DRB Application No.: 08DRB-70500 Project # 1006964  
 Project Name: GILLETTE ADDITION  
 Agent: JACKS HIGH COUNTRY Phone No.: 898-3707

**DRB CASE NO/PROJECT NO: 1006964**

**RE: Gillette Addition and Block 1, Evans Addition**

**PLAT OF
LOTS 2-A AND 3-A
GILLETTE ADDITION
AND
LOTS 3-A, 5-A AND 7-A
BLOCK 1
EVANS ADDITION**

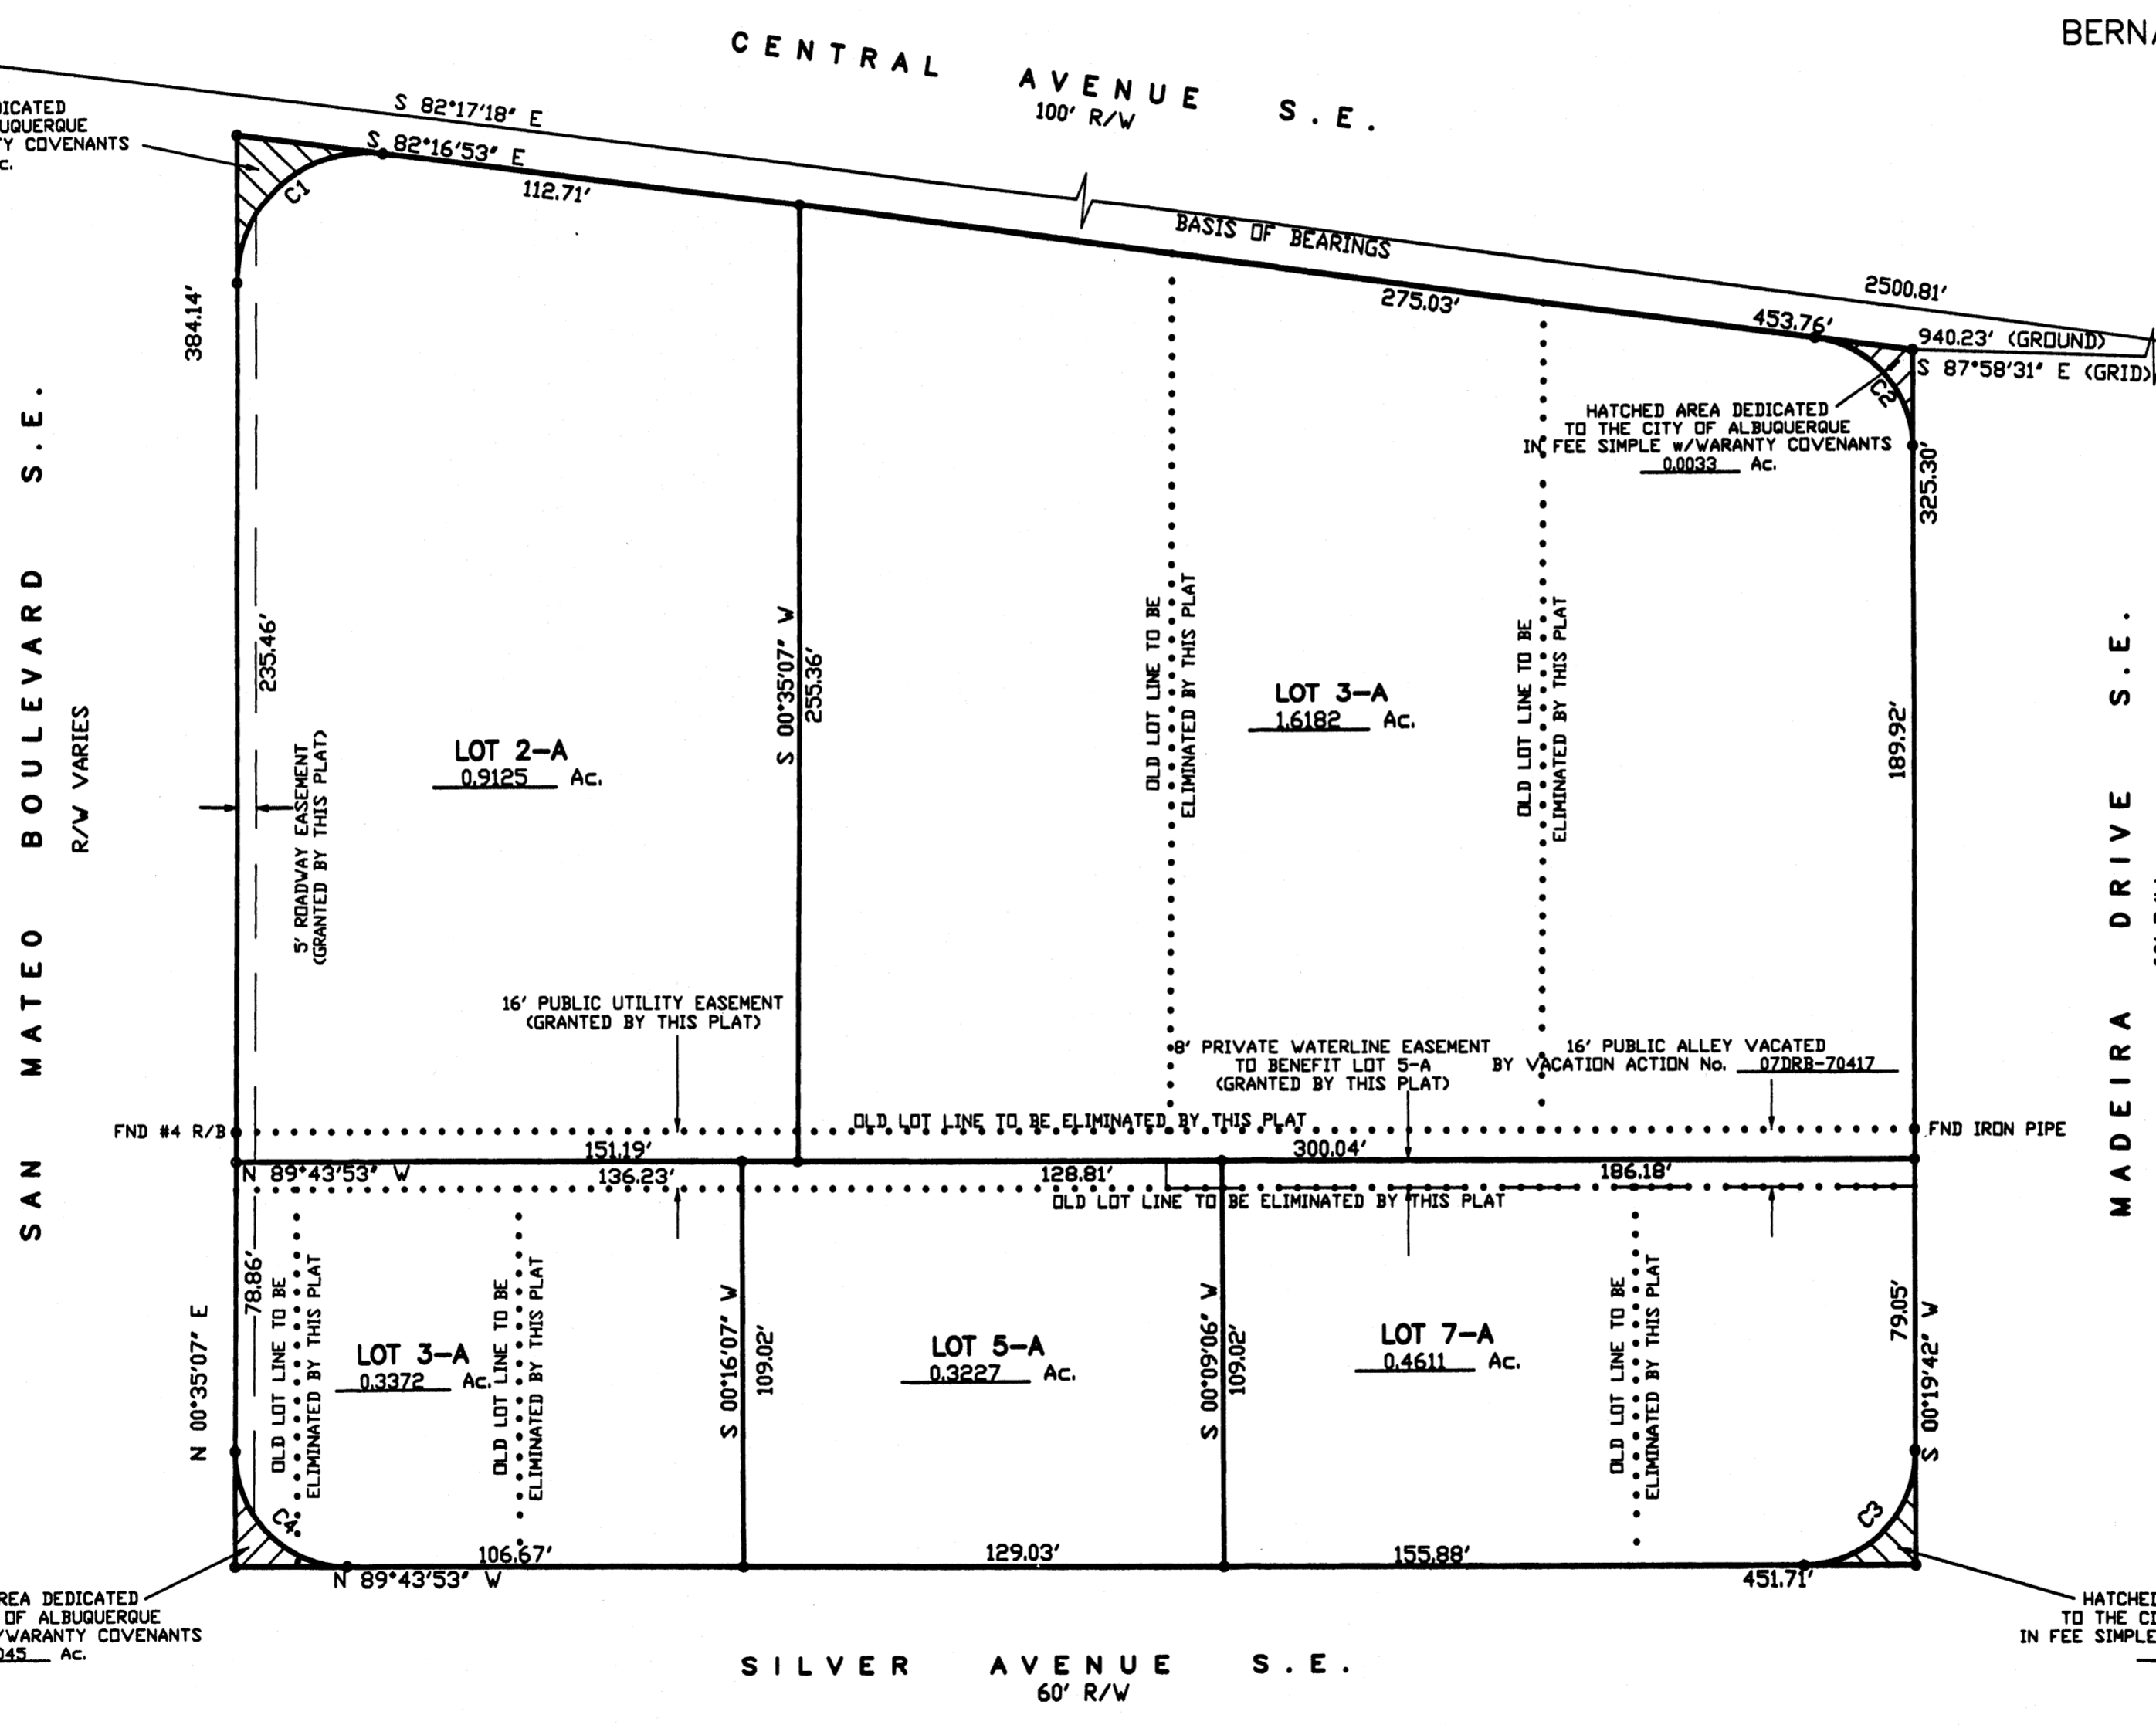
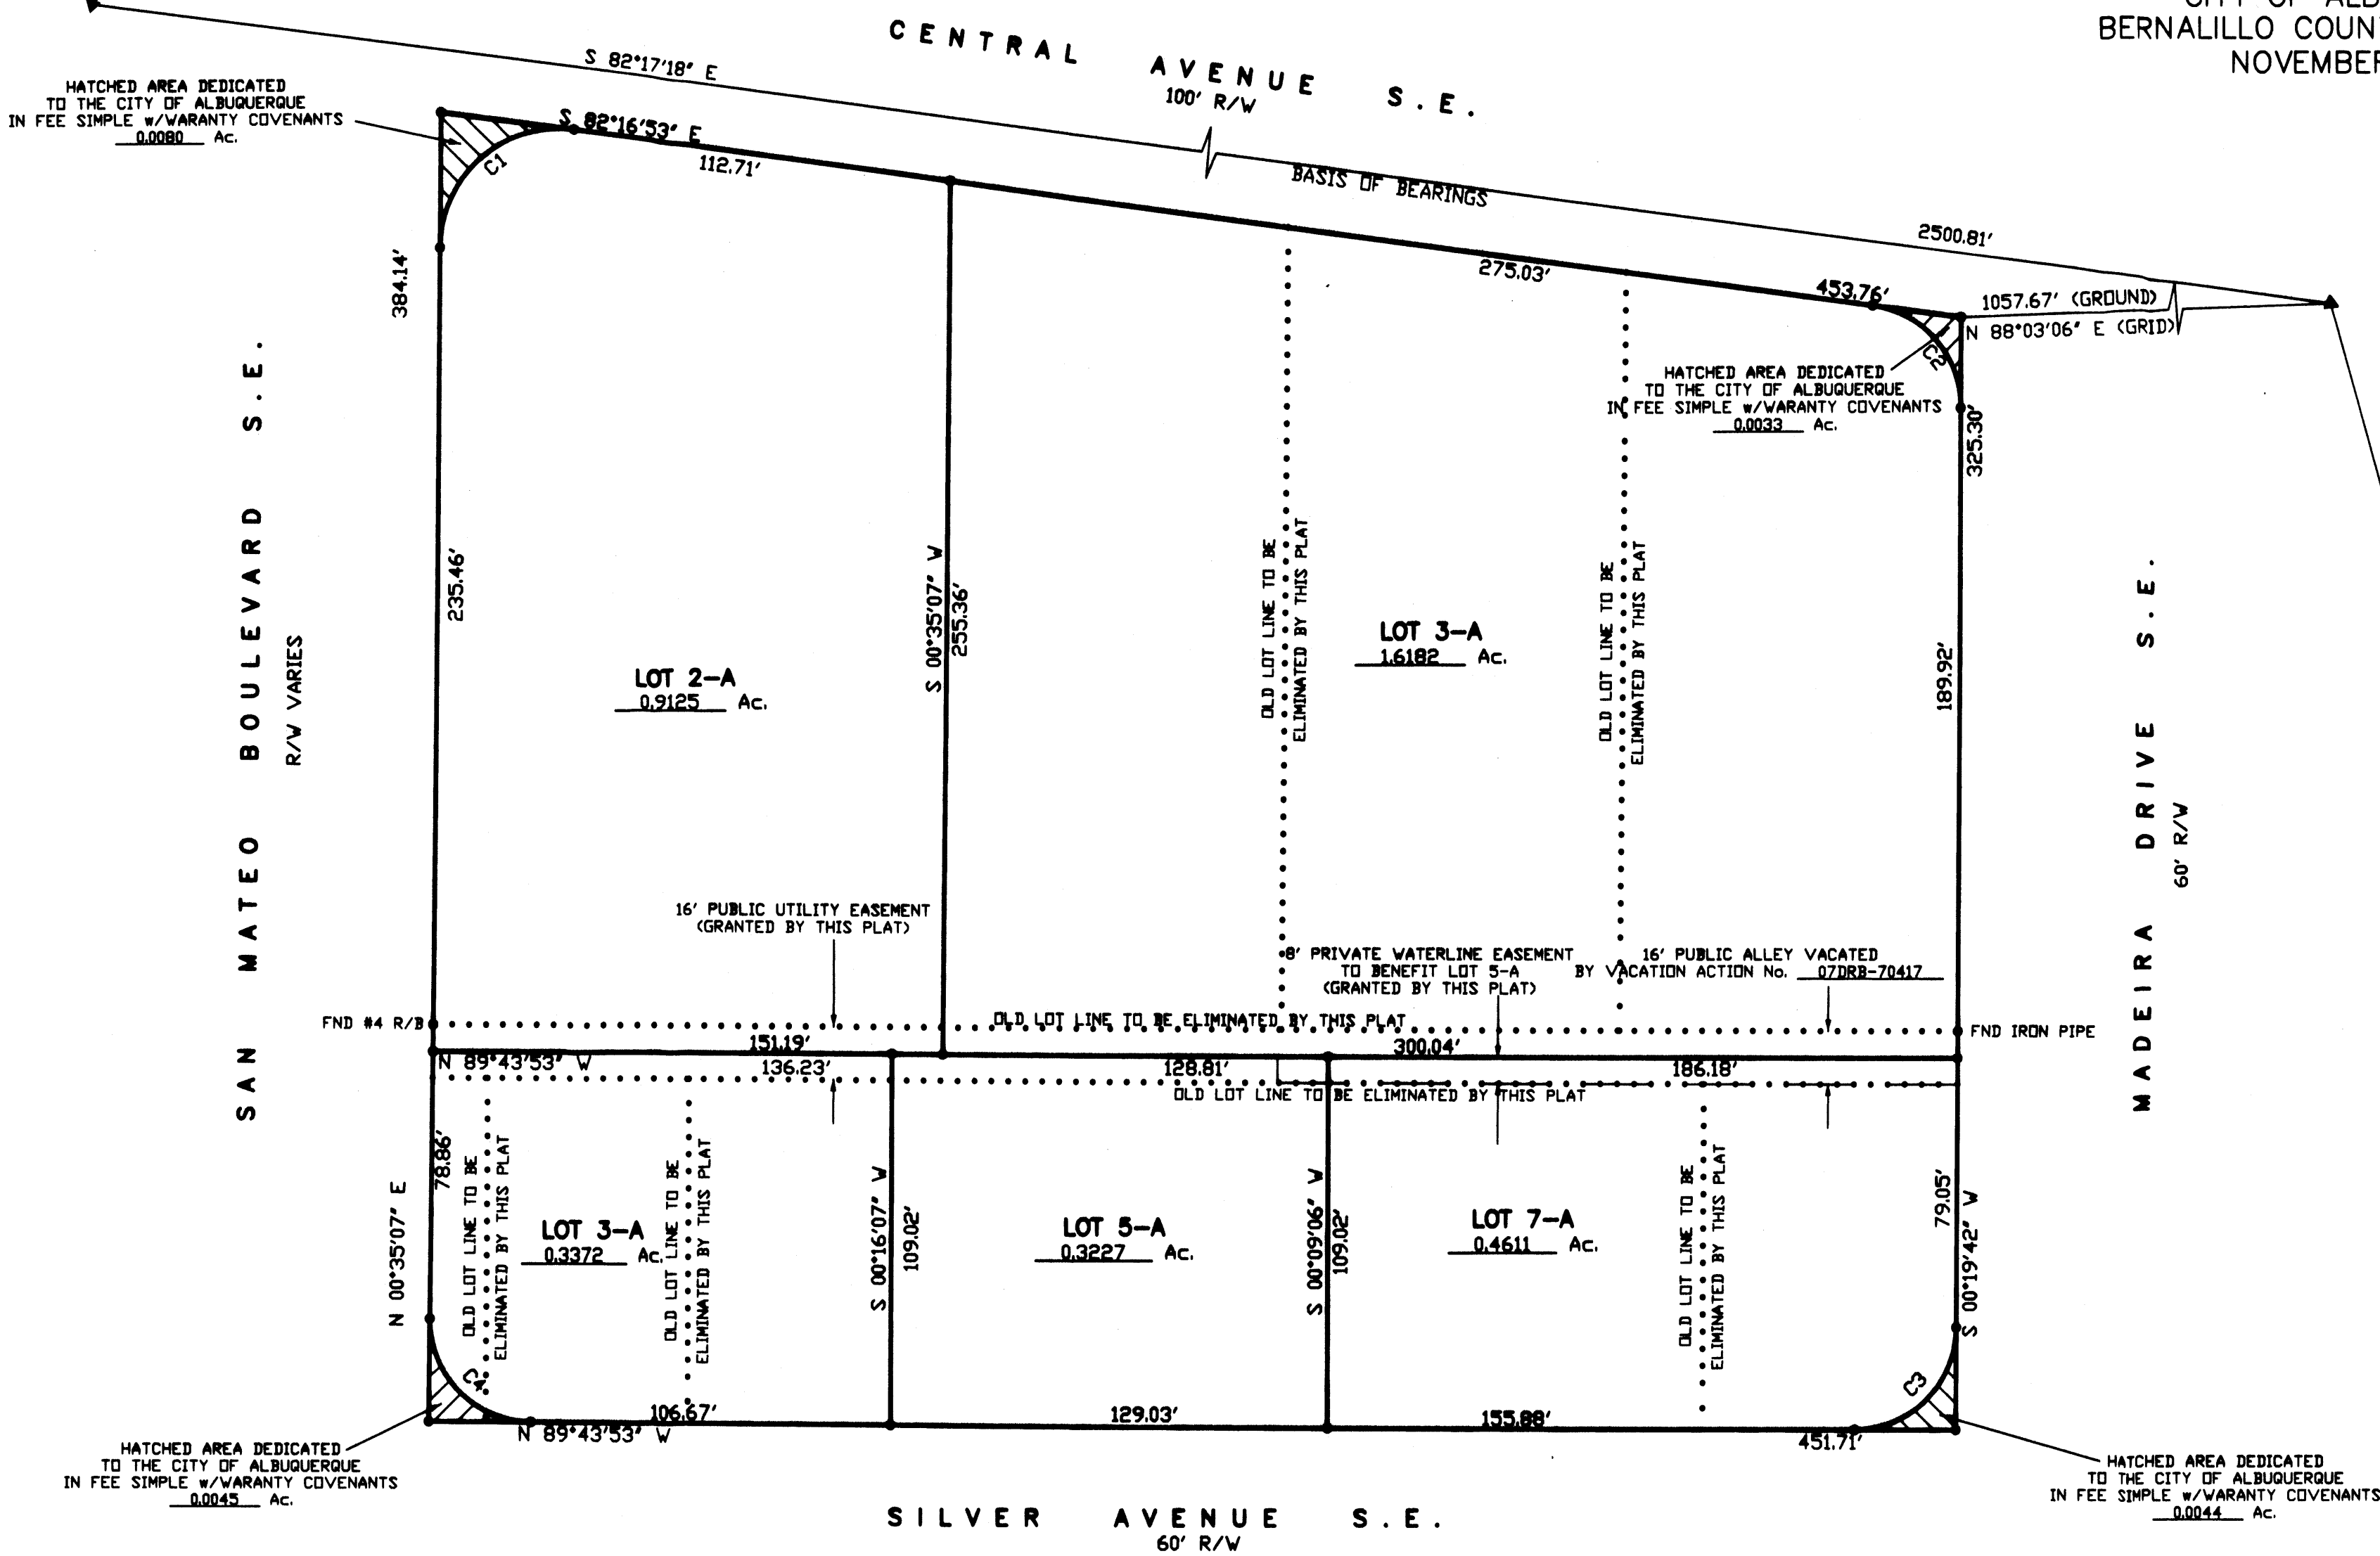
PLANNING (Last to sign): - Roadway Easement  
 \_\_\_\_\_  
 \_\_\_\_\_

Need private drainage easement retained through alley unless the hotel is to be redeveloped..

A detailed site plan that shows parking (and parking calculations) is needed to demonstrate that each lot can individually meet zoning requirements – it appears Lots 1-A and 2-A will need to be combined, as well as Lots 4-A through 6-A. A re-plat must be filed by the end of this year or the vacation will expire.
